From: [Brenda Larsen](#)
To: [Jeff Watson](#)
Subject: RE: BL-10-00042 Sun Country
Date: Tuesday, November 30, 2010 8:22:42 AM

After conducting a review of the above named project, I have the following comments:

PROPOSED

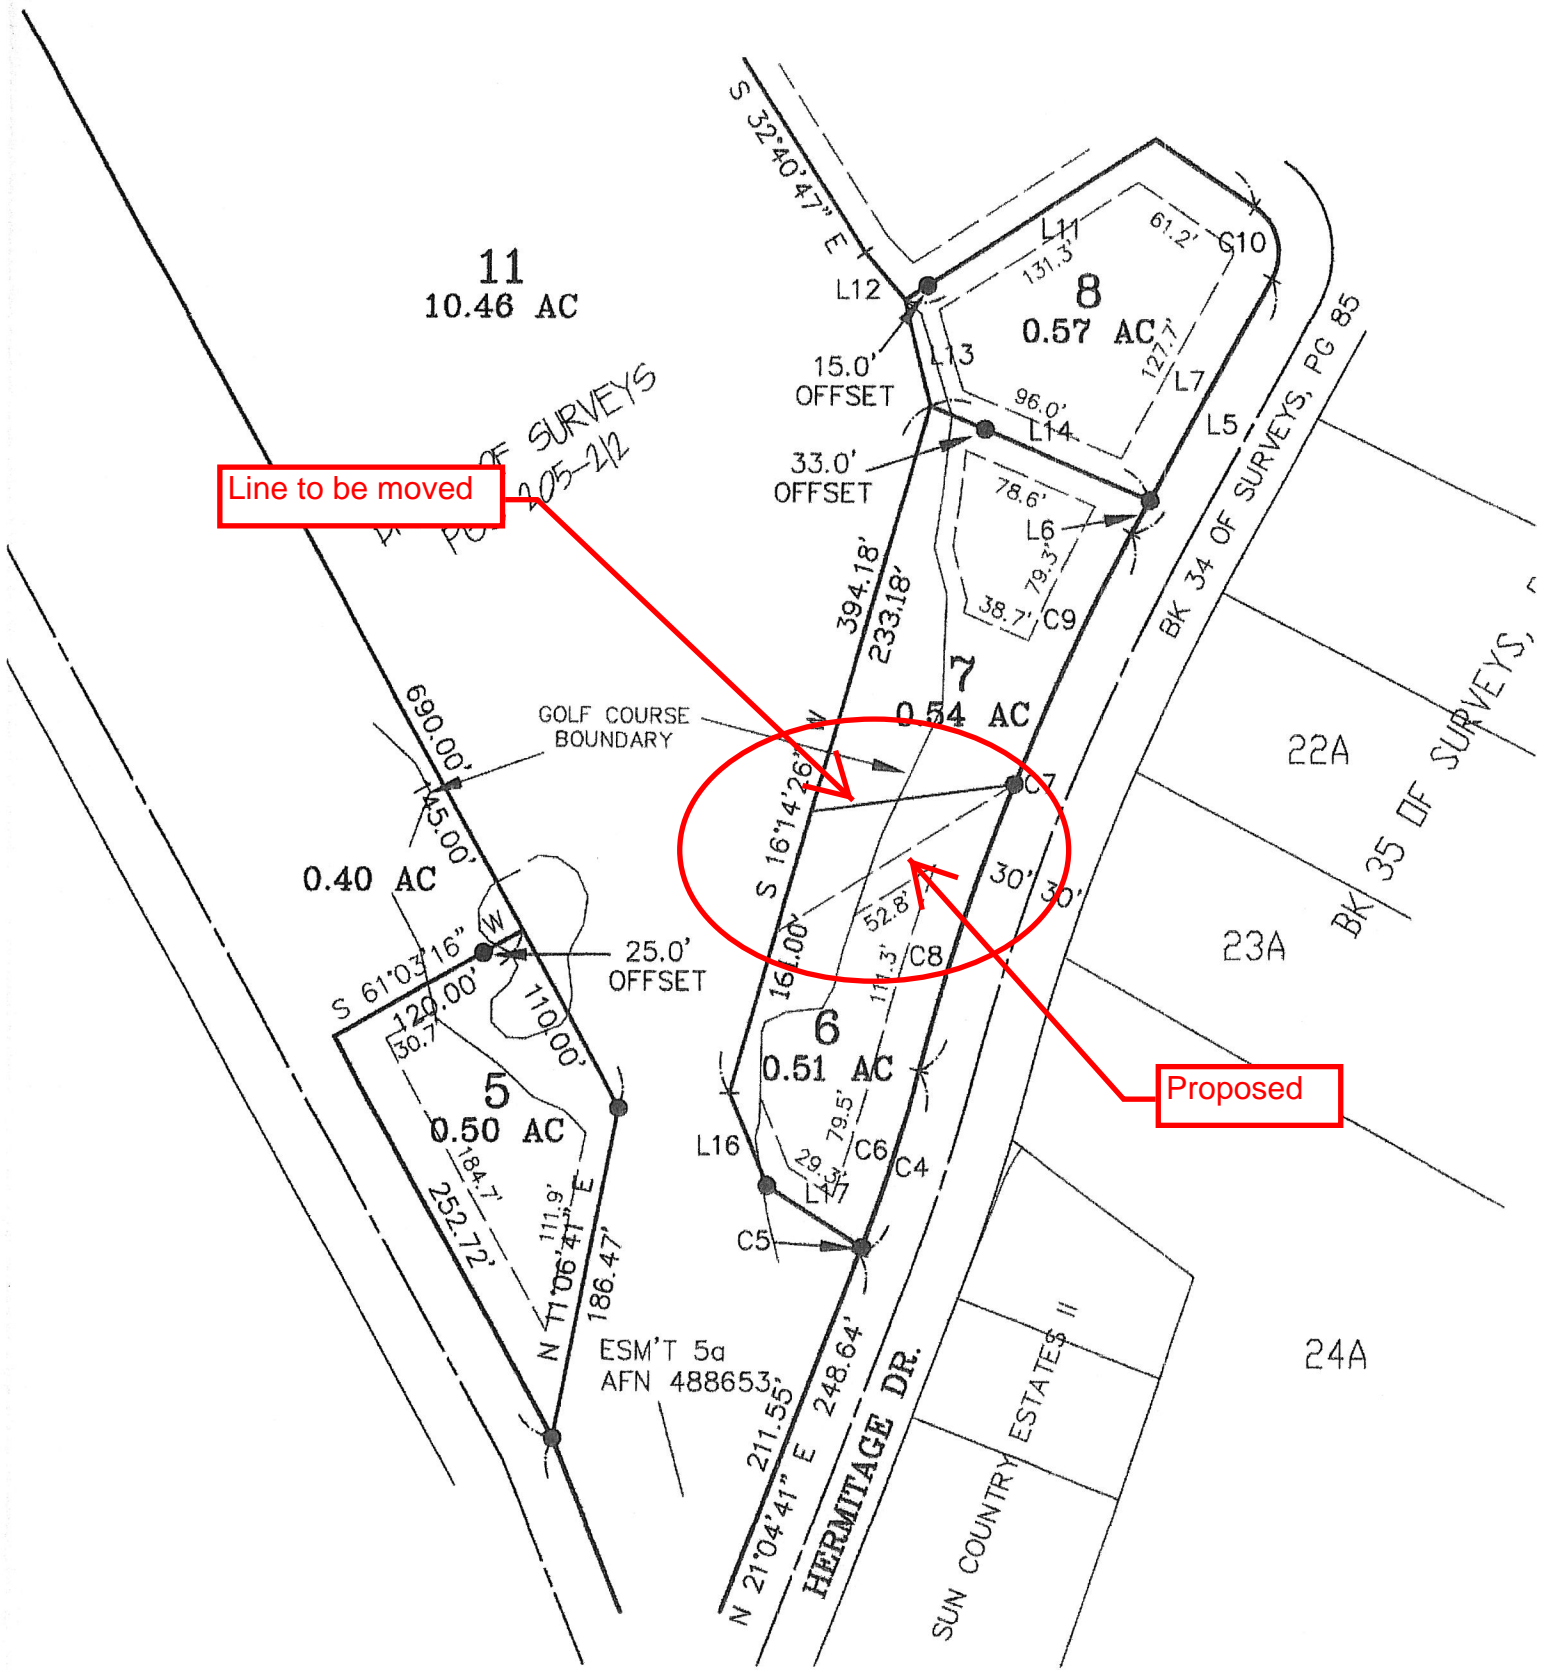
- Ensure that boundary line adjustments do not infringe upon existing structures, to include propane tanks, etc.
- Creation of any additional roads or access must comply with the International Fire Code.
- All future development must comply with the International Fire Code.
